**RE: STATE SIGNIFICANT DEVELOPMENT APPLICATION (SSD 10422) FOR PROPOSED BRICKWORKS PLANT**

**PROPERTY AT: 416 & 524 BERRIMA ROAD, MOSS VALE (LOT 1 DP 785111 & LOT 1 DP 414246)**

<b>Table 1: Response Matrix</b>	
<b>Relevant Entities Response to Submissions</b>	<b>Formalised Response</b>
<b>NSW Department of Planning, Industry and Environment (Chris Ritchie – Director – Industry Assessments)</b>	
<p>1. <i>The Department notes the consistent concern raised in all submissions made by the general public and public interest groups is the provision of renewable energies for site operations to reduce greenhouse gas (GHG) emissions. The Department requests the Applicant provide an assessment of renewable energy opportunities that could be incorporated into the development. The assessment should discuss the costs and benefits of identified renewable energies and justify why the identified renewables will or will not be considered for the development.</i></p>	<p>It is noted, that Brickworks continues its commitment to reduce energy use and carbon emissions. A range of energy reduction initiatives / measures proposed by Brickworks across their entire operations, including the proposed Brick

OVERALL FLOOR
PLAN

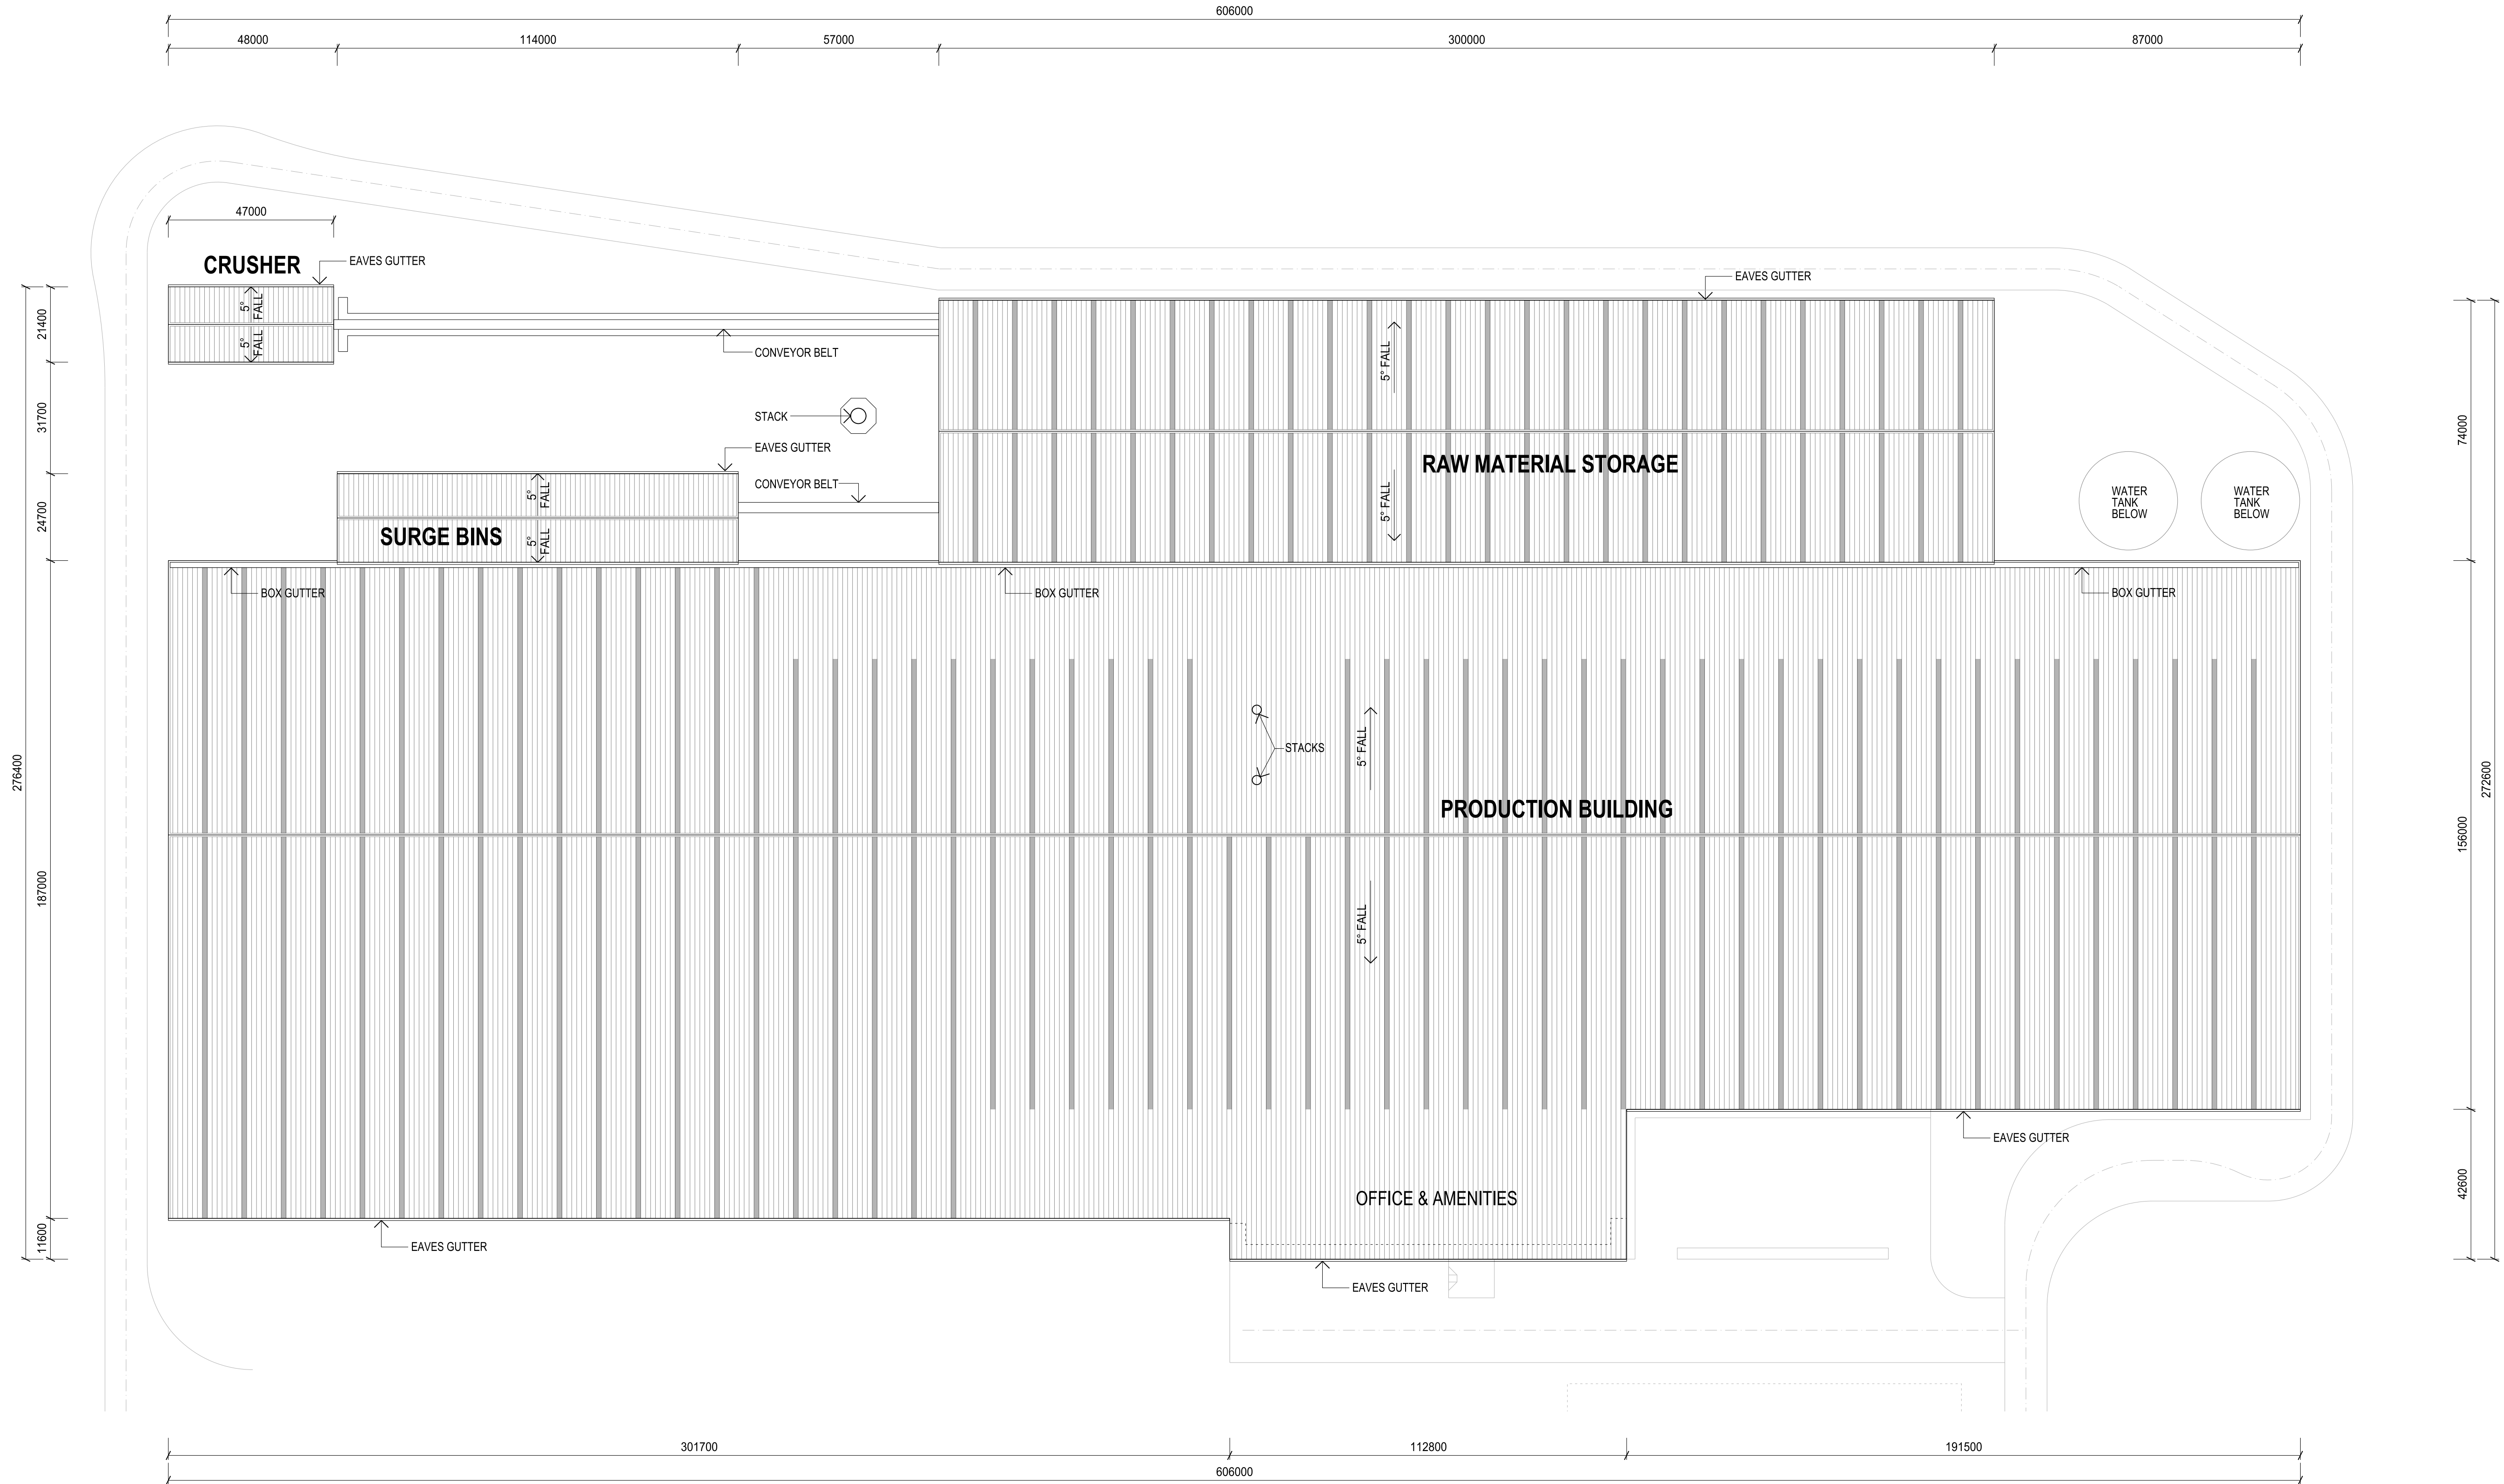
<p>2. <i>The EIS identifies that there are five stages involved in the proposed production process of bricks for the development. However, it is unclear how the five production stages for processing bricks are undertaken on the site. The Department requests an annotated facility floor plan and flow diagram which demonstrates how each production stage is undertaken within the site and the plant and equipment utilised for processing.</i></p>	<p>A Flow Diagram has been prepared and is attached in <b>Appendix 2</b> of this Submission capturing the operational stages of the Proposal.</p>
<p>3. <i>The Department notes the development will produce a specialty brick product referred to as 'Bowral Blues'. The Department requests clarification on the different types of brick products proposed to be produced, the approximate weight and volume of each brick type proposed to be produced, the different processes required for the manufacturing of each brick type and the amount of resources required for each brick type.</i></p>	<p><b>Appendix 3</b> of this Submission includes a breakdown pertaining to the varied bricks to be manufactured and produced in the proposed Brick Manufacturing Facility. Additionally, Brickworks note the following:</p> <ul style="list-style-type: none"> <li>▪ “Bowral Blue” is the most popular colour in the Bowral dry press brick range and is currently manufactured in various brick shapes at the existing Bowral operational site. All bricks and special shapes will continue to be manufactured in this colour at the proposed Brick Manufacturing Plant.</li> <li>▪ The proposed Brick Manufacturing Plant will manufacture all other products currently manufactured at the existing Bowral dry press plant (standard dry press bricks and various dry press shapes).</li> <li>▪ With the introduction of new technology and equipment the proposed Brick Manufacturing Plant will also be configured to manufacture a new range of products; large format bricks (Modulars) and large format pavers.</li> </ul>
